TfNSW Reference: SYD21/00813/03
Client Reference: SSD-23512960

RESPONSE TO SUBMISSIONS FOR GLENWOOD HIGH SCHOOL - 85 FORMAN AVENUE, GLENWOOD

TfNSW would provide further comments, in the attachment, regarding the School Travel Plan (STP) for the Department's consideration.

Figure 3.2: New proposed pedestrian access point

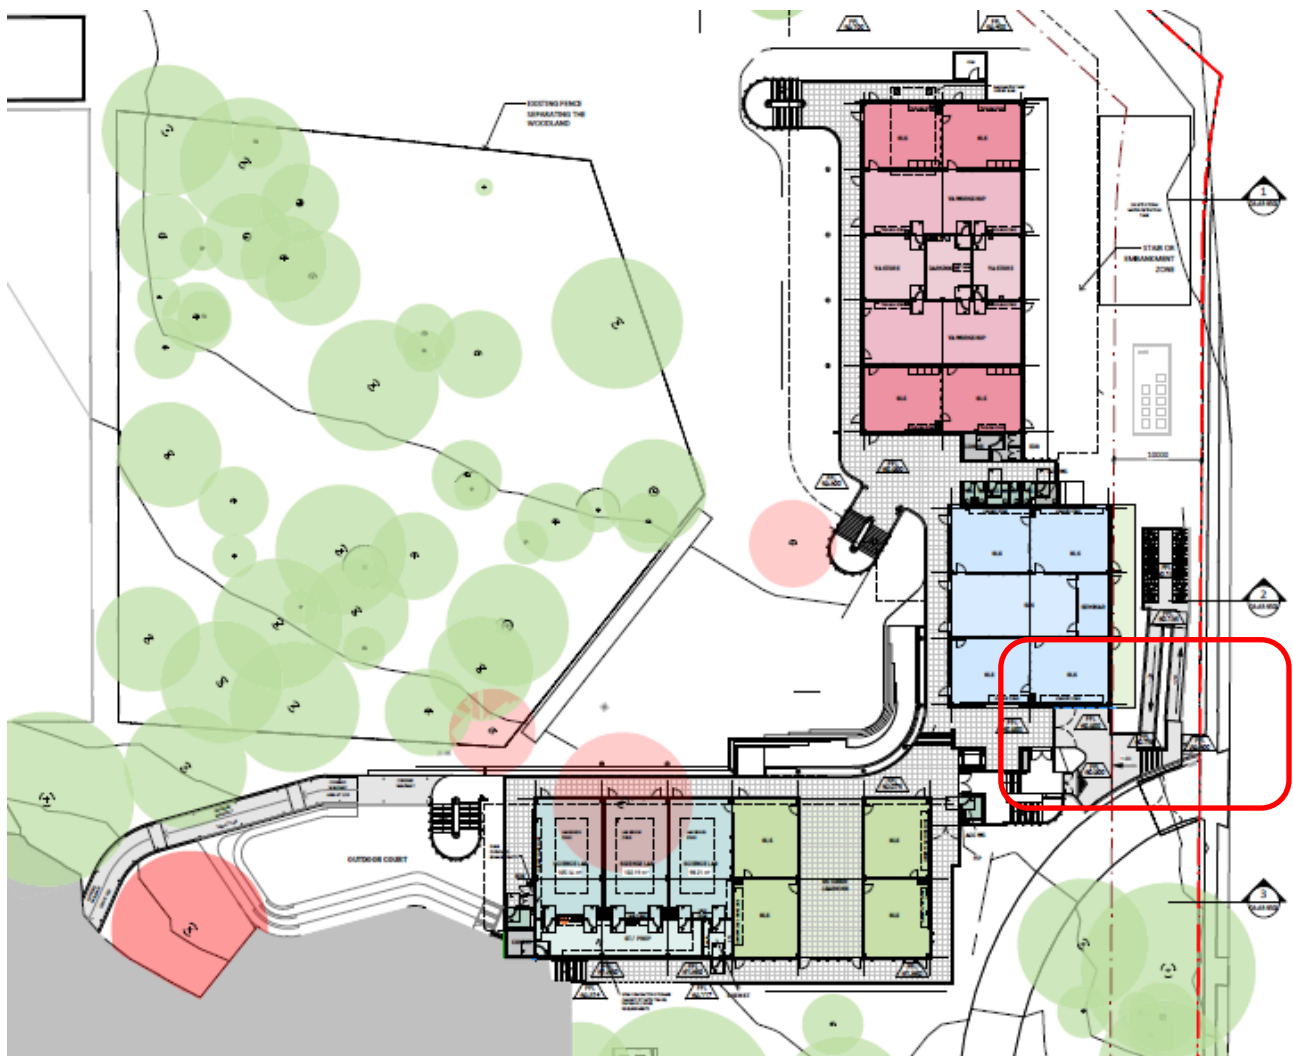
In order for the School Travel Plan to be successful implementing proposed increases to active transport mode shares, pedestrian infrastructure upgrades will need to be implemented; TfNSW notes the high priority put on these upgrades for this development; that current movements result in some level of conflict and crossover between pedestrians and vehicles, therefore requiring safe management. TfNSW would like to confirm that the timing of these upgrades will be **completed prior to occupancy**.

Figure 3.3: Proposed layout of the end-of-trip facilities

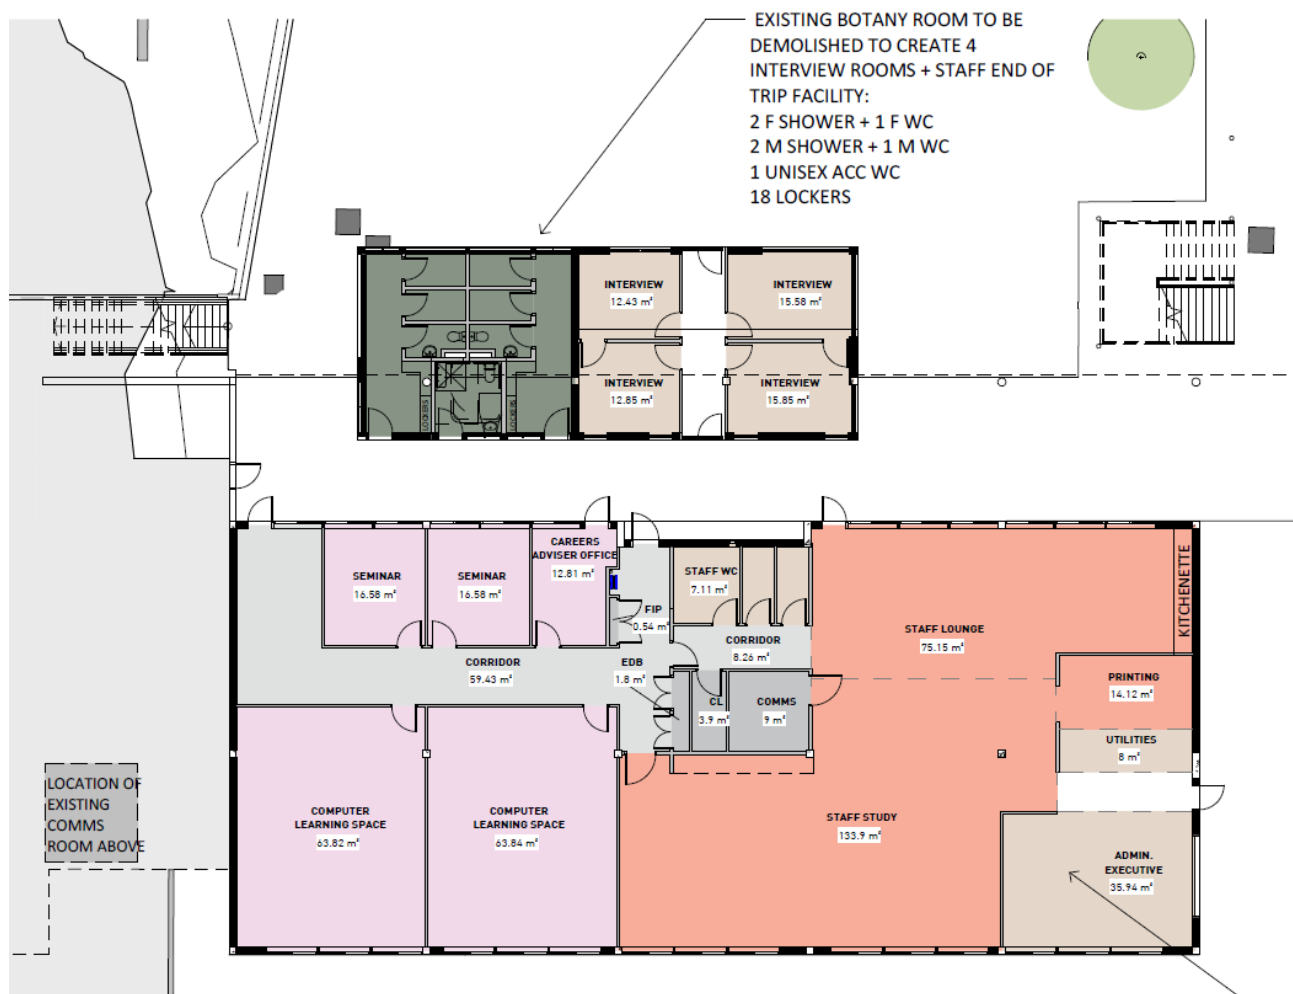
TfNSW recommends the applicant provides sheltered, and secure bike racks to encourage more staff and students to use bikes. Bicycle parking use should be reviewed on a regular basis, to ensure that there is good provision to encourage more cycling, and these facilities should also be promoted in the Implementation Strategy. It is noted that EoTF have been provided for staff, but consideration be given to an increase in the provision of lockers, which is currently proposed to be 18 lockers.

Figure 5.1: Travel Access Guide public transport template
Source: School Infrastructure NSW

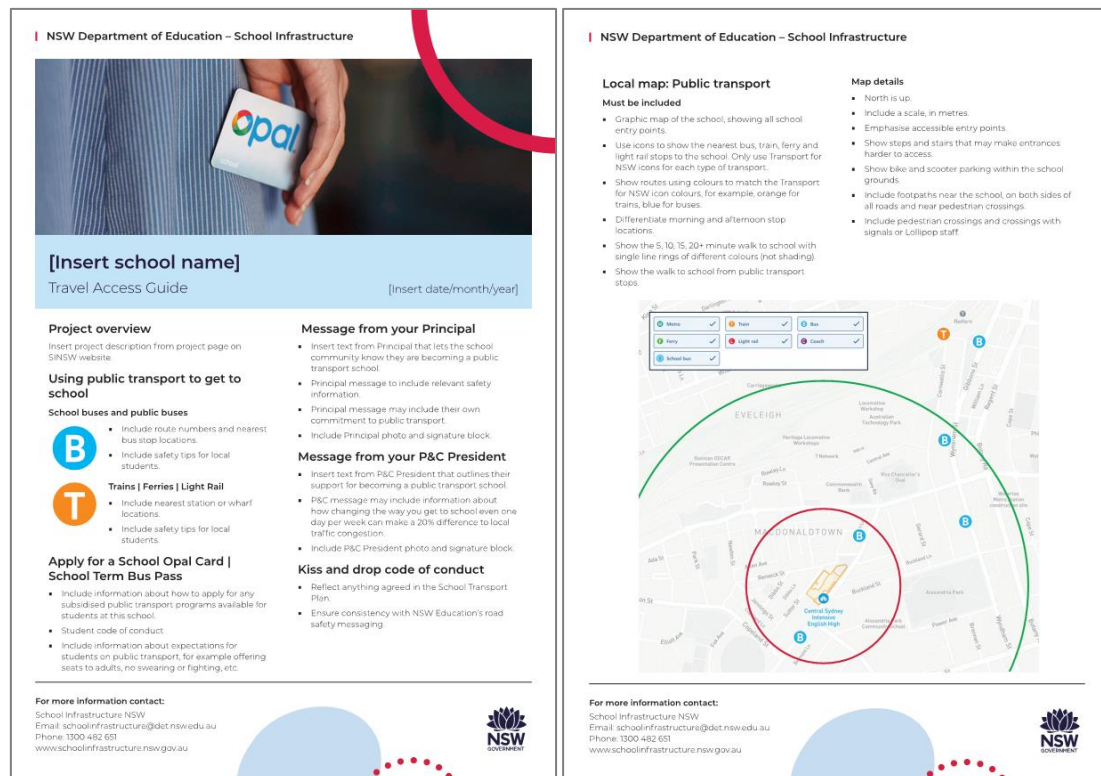
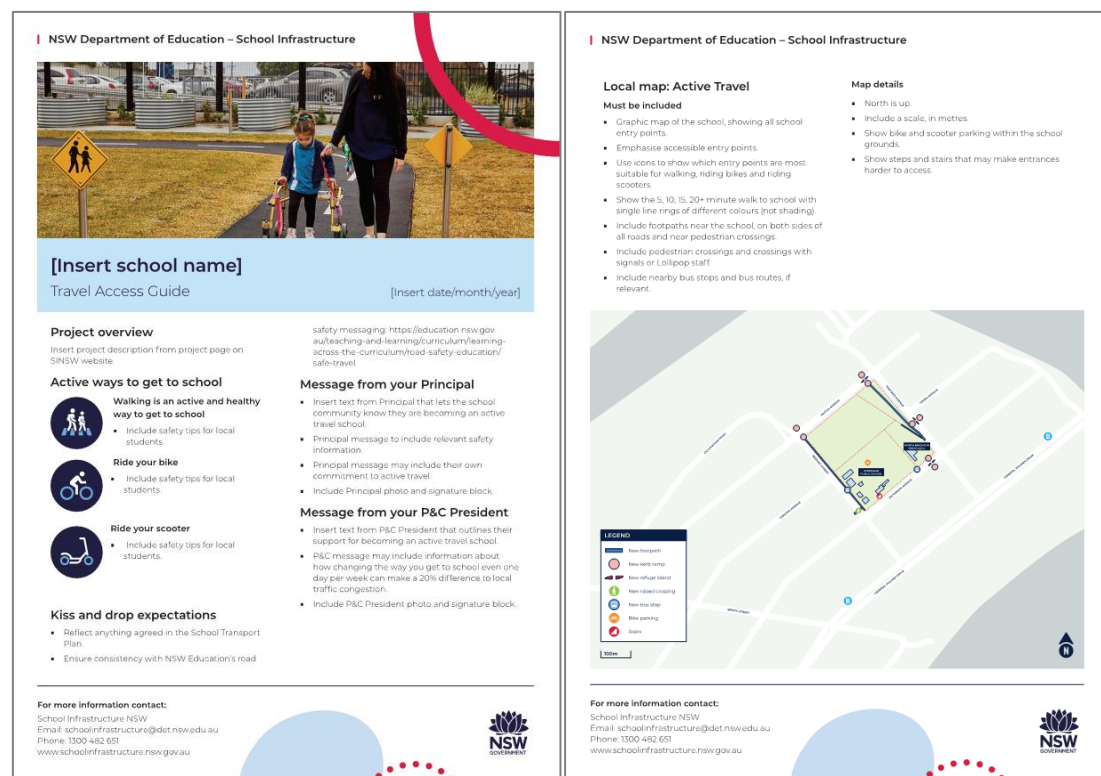
TfNSW appreciate that there is an initiative to do a Travel Access Guide, however separate appendices with the proposed Travel Access Guide customised for the school (rather than

a generic template) should be provided. This will include a high quality Travel Access Guide (TAG) which provides information to staff, students and visitors and patrons about how to travel to the site by sustainable transport modes. The TAG should:

- Provide information advising staff and students (at the beginning of each term) that additional information about service routes and timetables for buses and trains is available on the Trip Planner at transportnsw.info/
- Provide information advising patrons and staff and students that additional information about cycling routes is available on the Trip Planner at transportnsw.info/
- Provide promotion of end of trip facilities, including the new cycling infrastructure available, and update number and location of bike parking facilities and End of Trip facilities, and locate on TAG.
- For further helpful information – please access the document *How to Create a Travel Access Guide* via the link <https://www.mysydney.nsw.gov.au/travelchoices/resources>.
